Cc: Jamey Ayling <jamey.ayling@co.kittitas.wa.us>; Ellie Myers <ellie.myers@co.kittitas.wa.us>;
Bradley Gasawski <bradley.gasawski@co.kittitas.wa.us>
Subject: AU-26-00008 Sellers - Notice of Application

CDS is requesting comments on the following Accessory Dwelling Unit application: AU-26-00008 Sellers.

TO: All Staff
FROM: Public Works Plan Review Team
DATE: August 5, 2026
SUBJECT: AU-26-00008 Sellers

1 SITE PLAN 1" = 40'-0"

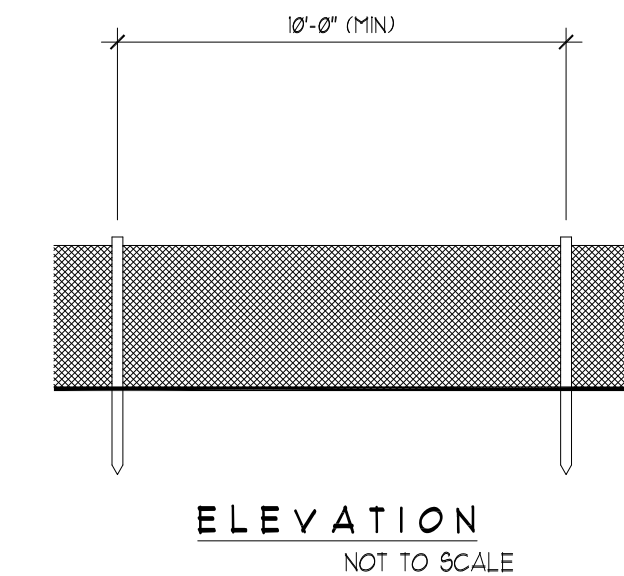
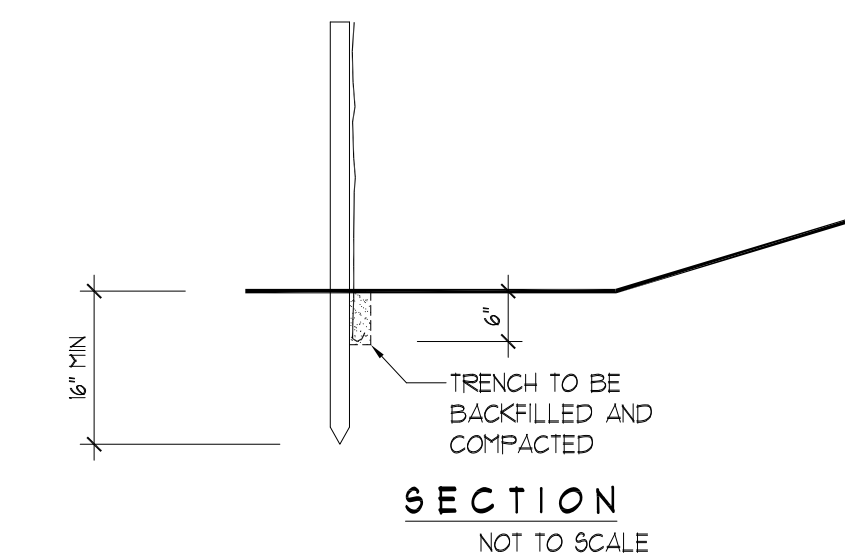
The new structure will need to meet county code for turnarounds if the driveway exceeds 150 feet.
